MEMORANDUM

Project name: Colvin PRD

PA22-015

Proposal: Planned Residential Development (PRD) and preliminary Binding Site Plan approval to construct 29 single-family detached units on 4.15 acres, utilizing MMC Chapter 22C.090 *Residential Density Incentives*, to increase the base density from 20 to 29-units. Two Administrative EDDS Variance have been requested, including reducing the PRD road ROW width from 50 to 45' and installation of a permanent hammerhead turnaround in lieu of a temporary cul-de-sac

PRELIMINARY ROAD & VAULT SECTIONS
COLVIN PRD

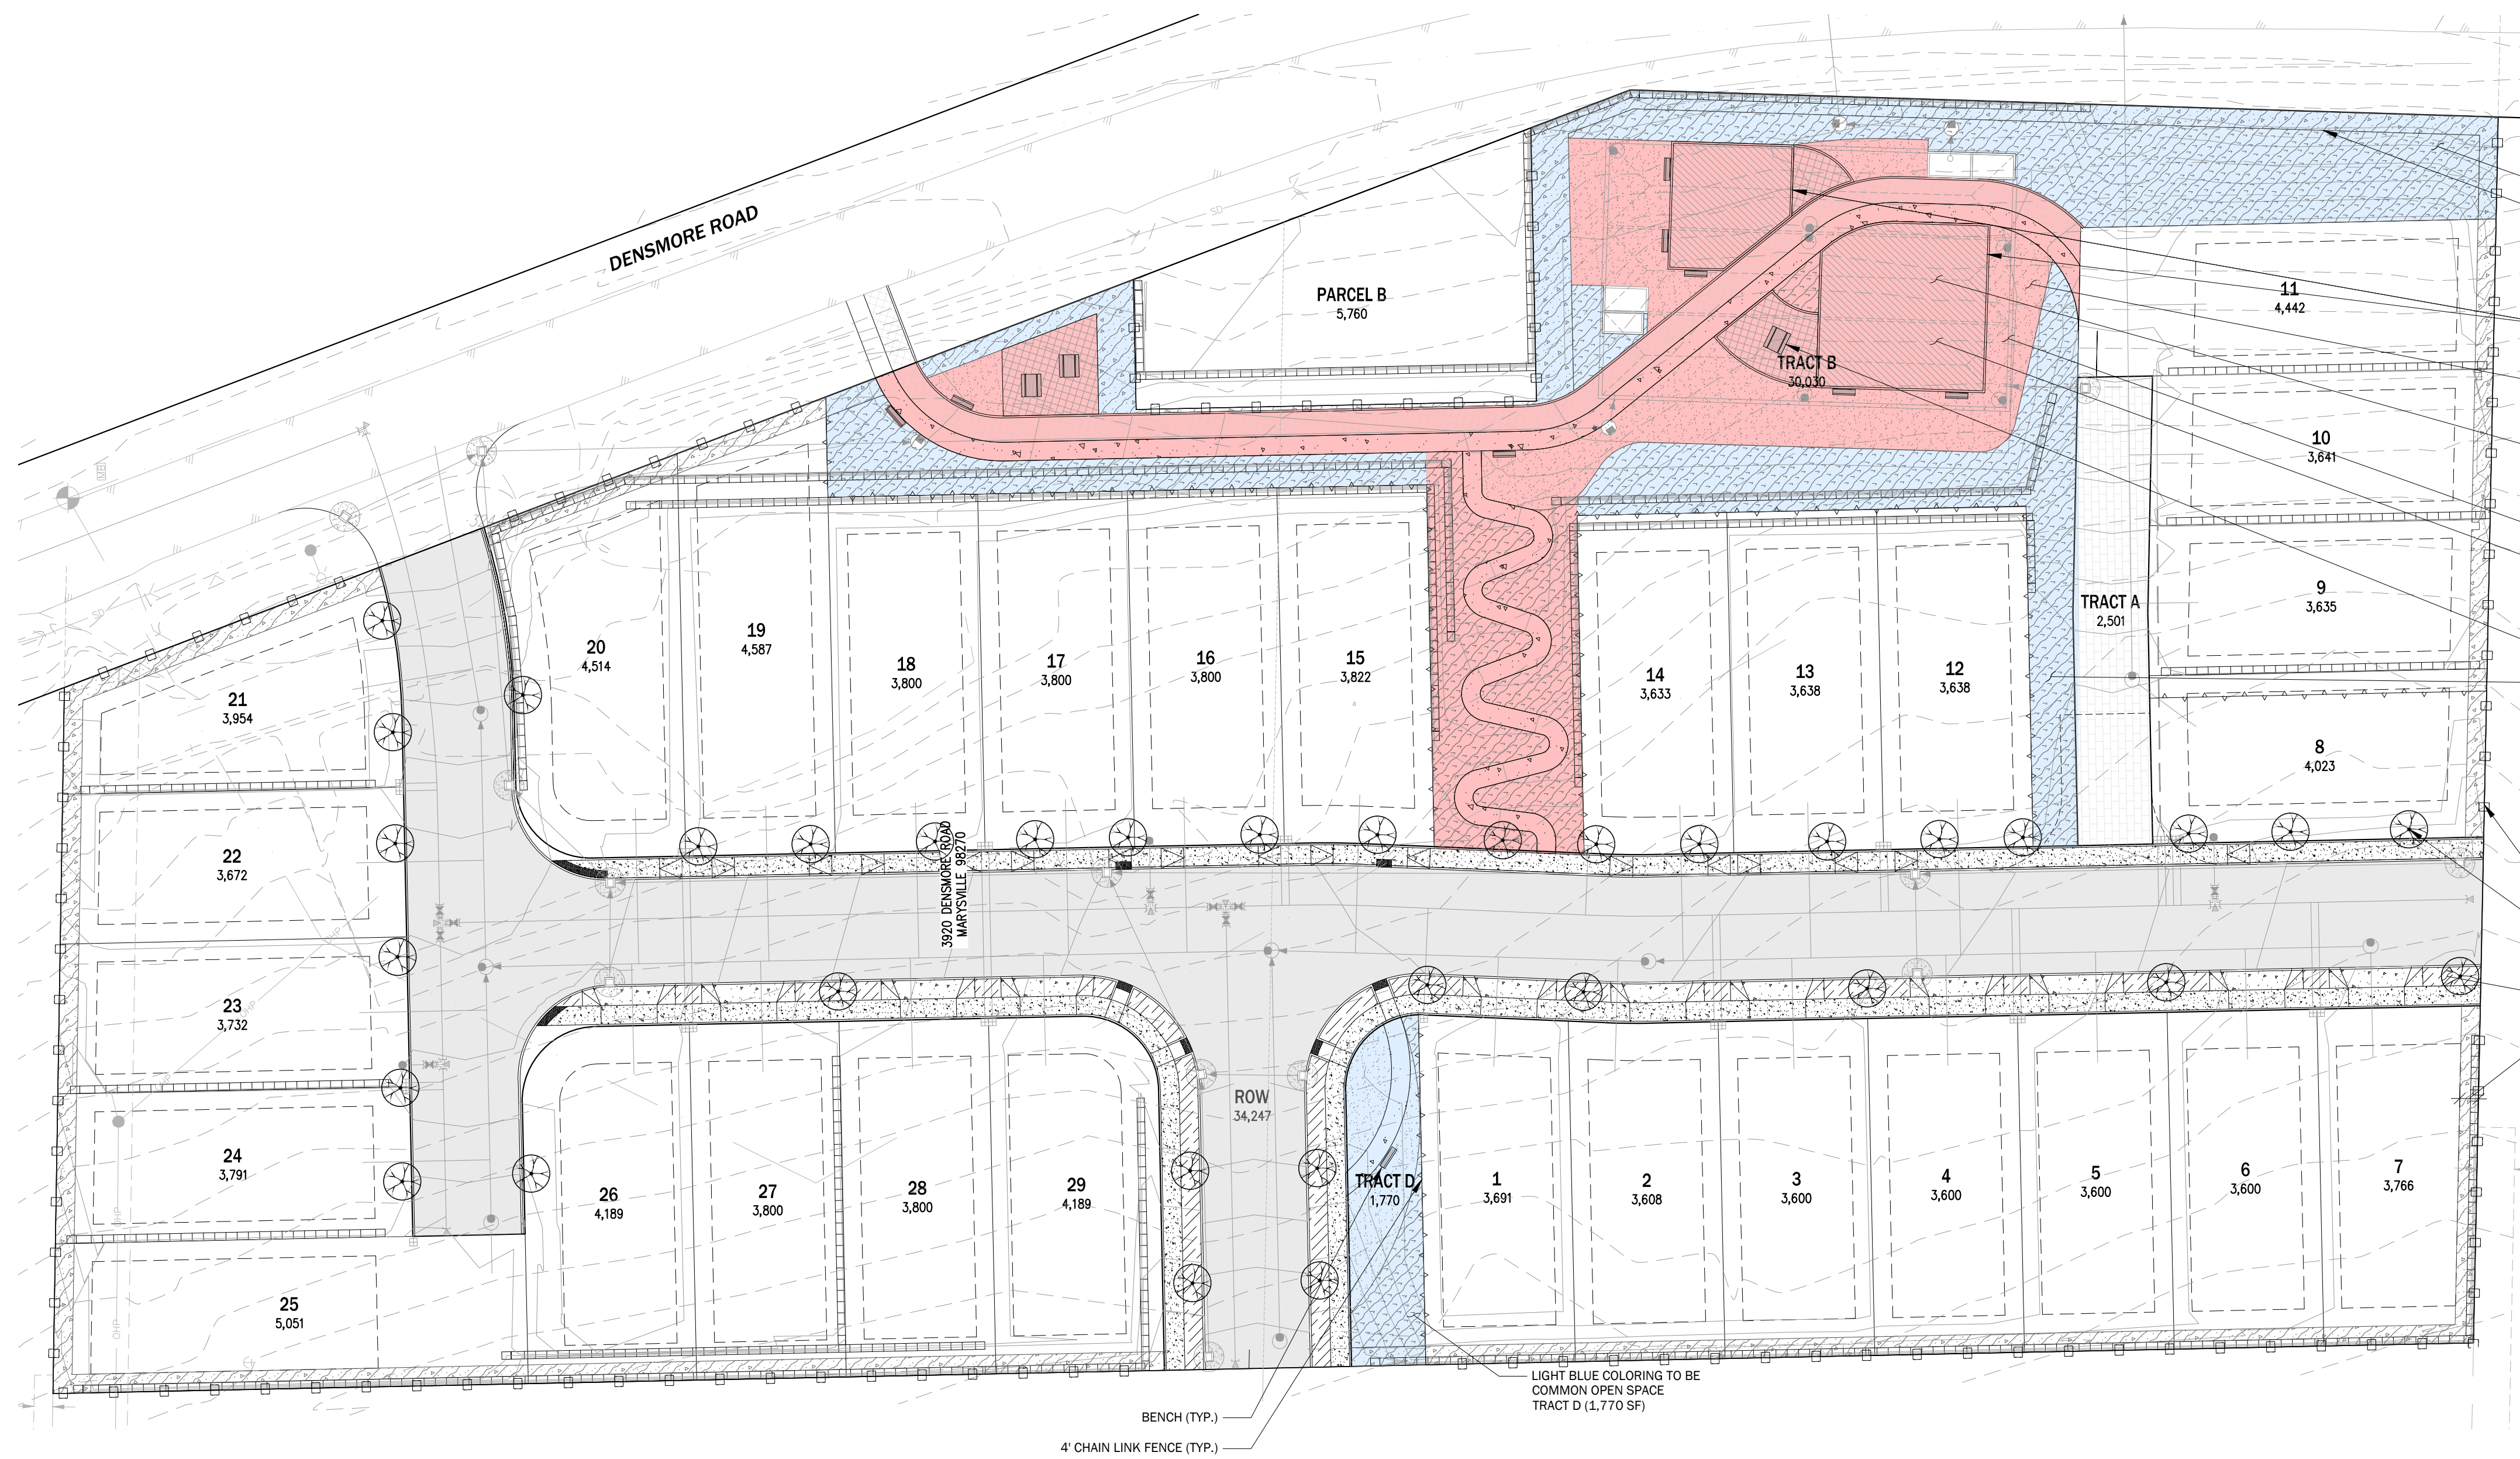
1. **Dedication Requirements:**
 - a. All new onsite roads will require right-of-way dedication.
2. **Access:**
 - a. Since this is a PRD project, MMC 22G.080.080 does allow some flexibility to modify the PRD Access Street section. In order to do this, a reduction of the planter strip requires offsetting landscaping that is “equivalent or greater landscaping to benefit the development”. If you’d like to pursue removal of the planter strip on one side of Roads ‘B’ &/or ‘C’, you would need to propose alternative landscaping that is acceptable to the City’s Planning Department. If not, both of these streets need to be built per SP3-218-001.

4. **Access for facility maintenance must be provided. A vactor truck must be able to drive to the inlet and outlet structures of the vault. All precast vault lids must be brought to the ground surface. All lids must be operable and cannot be obstructed by park amenities or landscaping.**
